Application for DCO by FOSSE GREEN  
Representation by Interested Party reference [REDACTED]  
Deadline 4

Summary of Submissions

Section B Comments on REP3-045- Applicant's response to ExQ2

Proposed Permissive Paths Plan

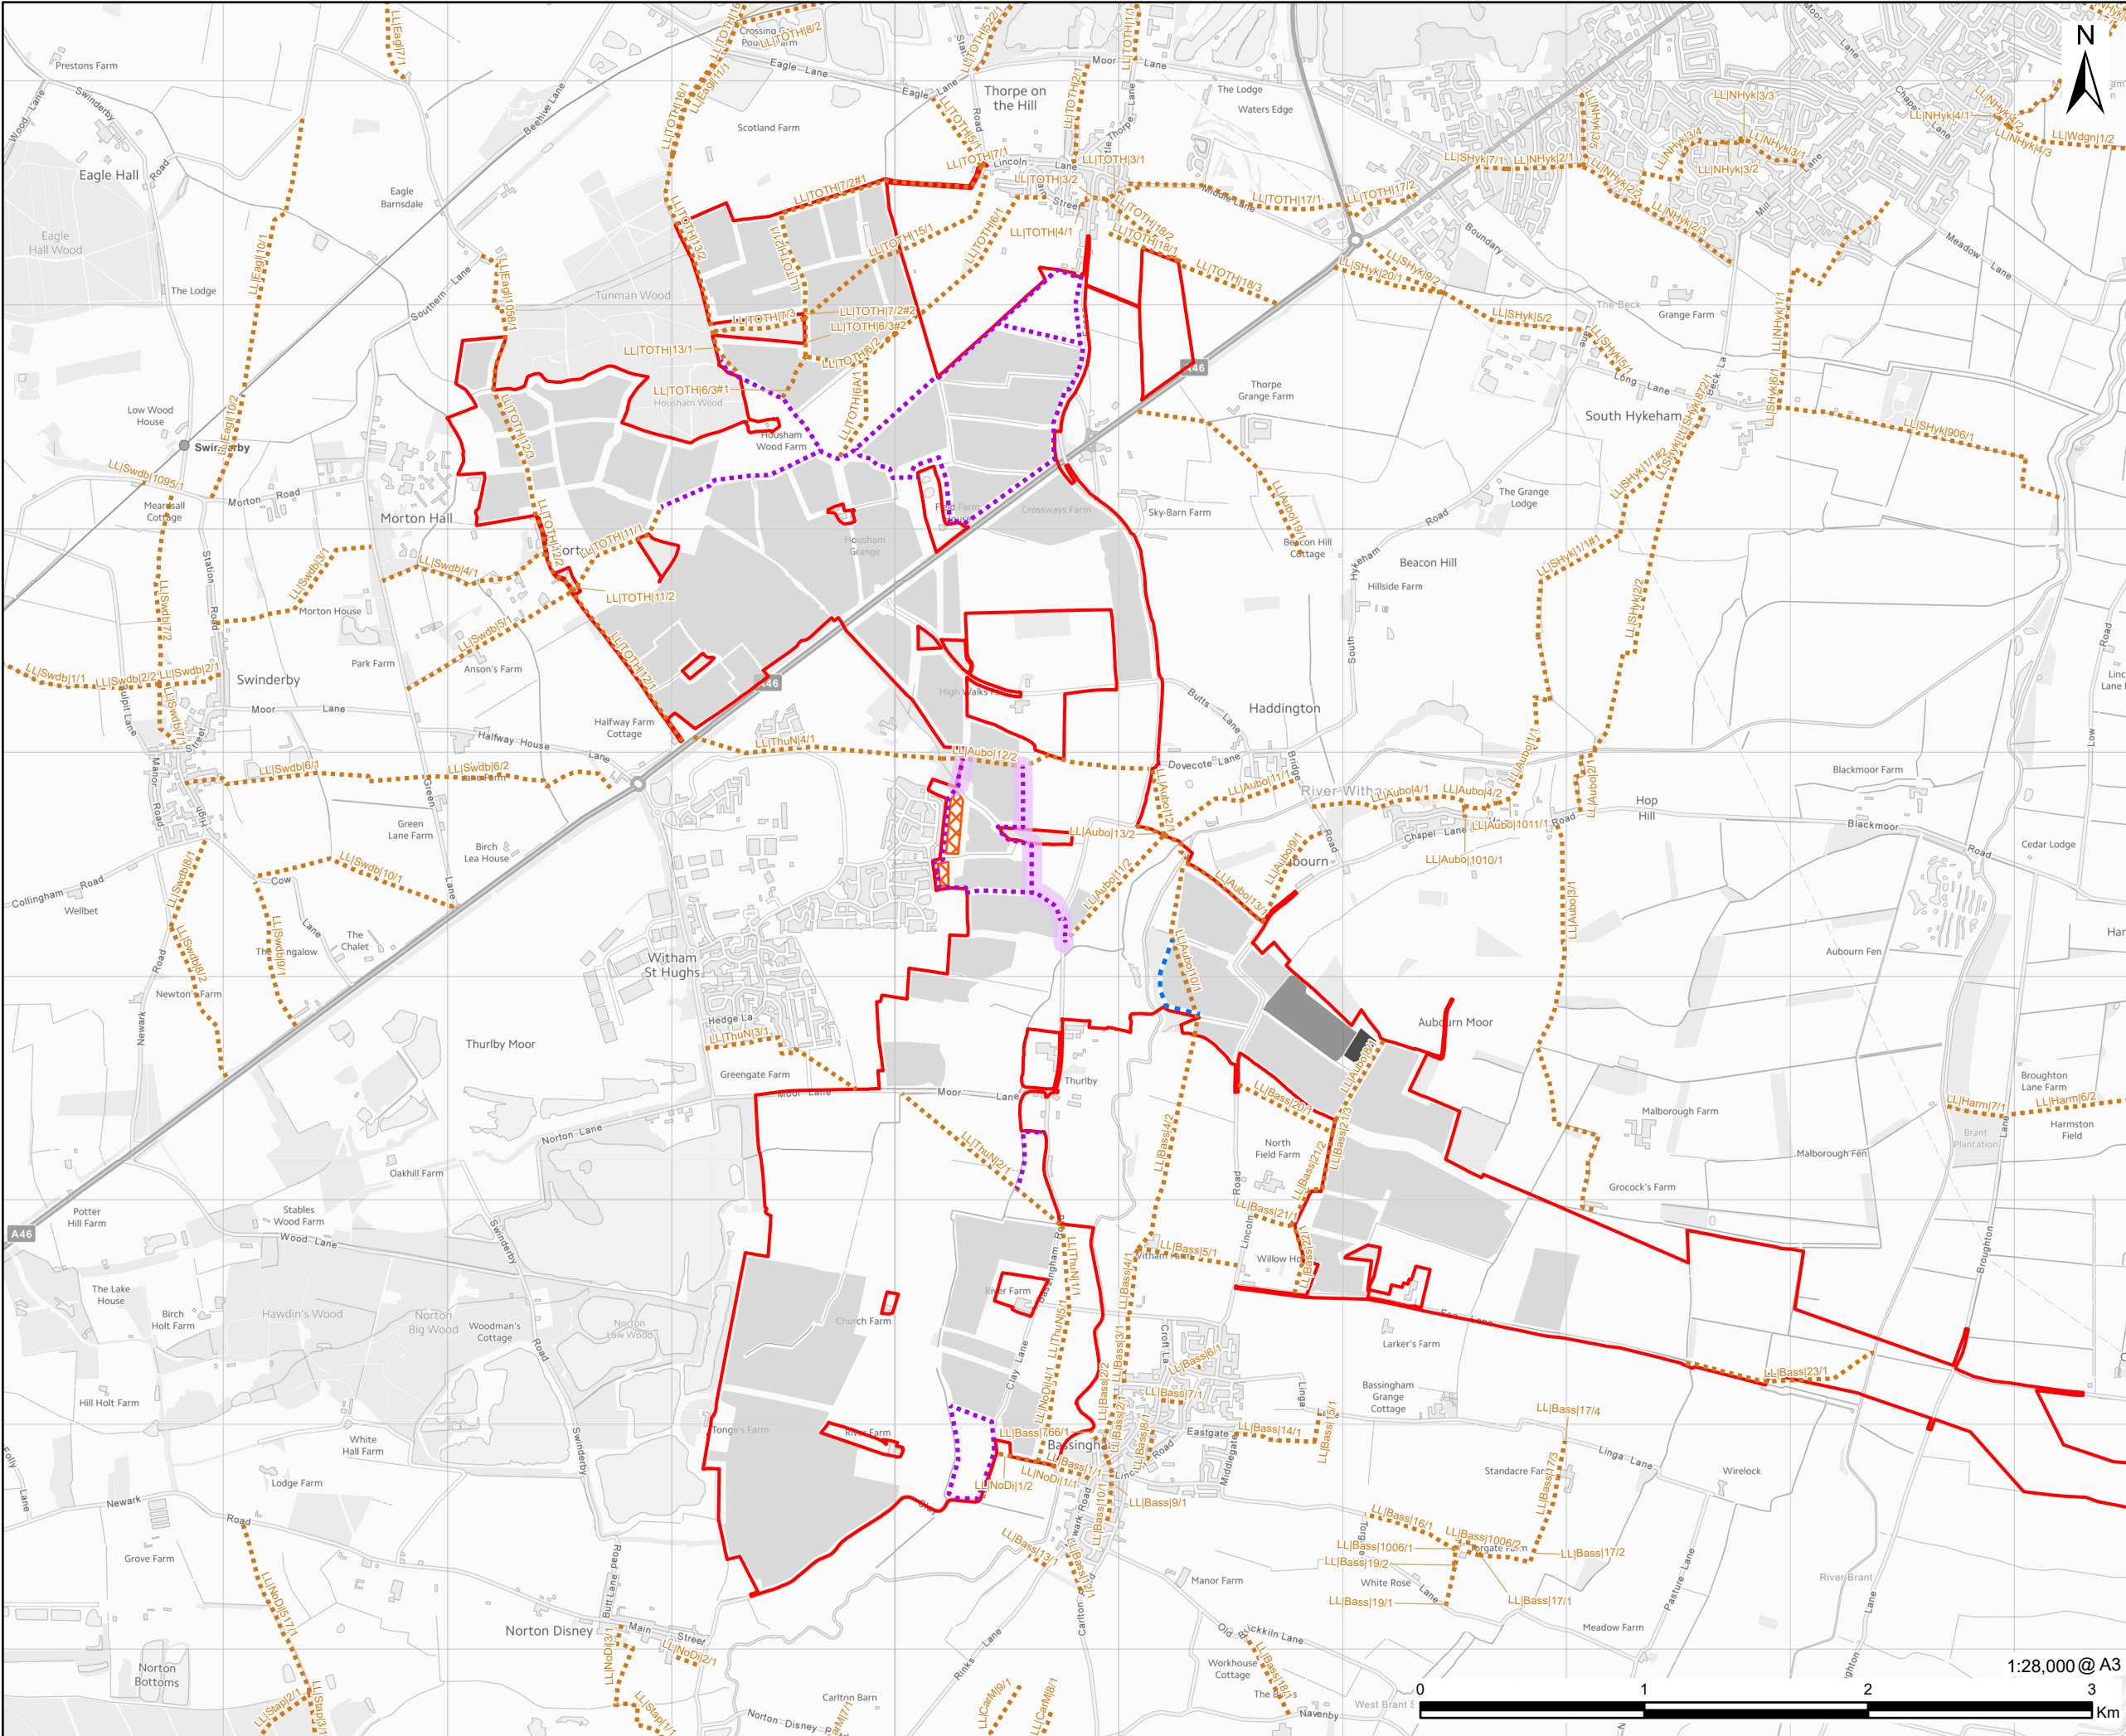
5.2.2 The route of the proposed new permissive paths mainly around Thorpe on the Hill will be around the edges of solar array fields where there will be noise from the BESS battery containers (if decentralised) and from the inverters, along the noisy A46, and along the existing busy Fosse Road running into Thorpe on the Hill. Rather than experiencing natural soundscapes, the predominant noise will be from vehicles and solar infrastructure which will adversely affect mental health rather than having inherent mental health benefits as the Applicant claims.
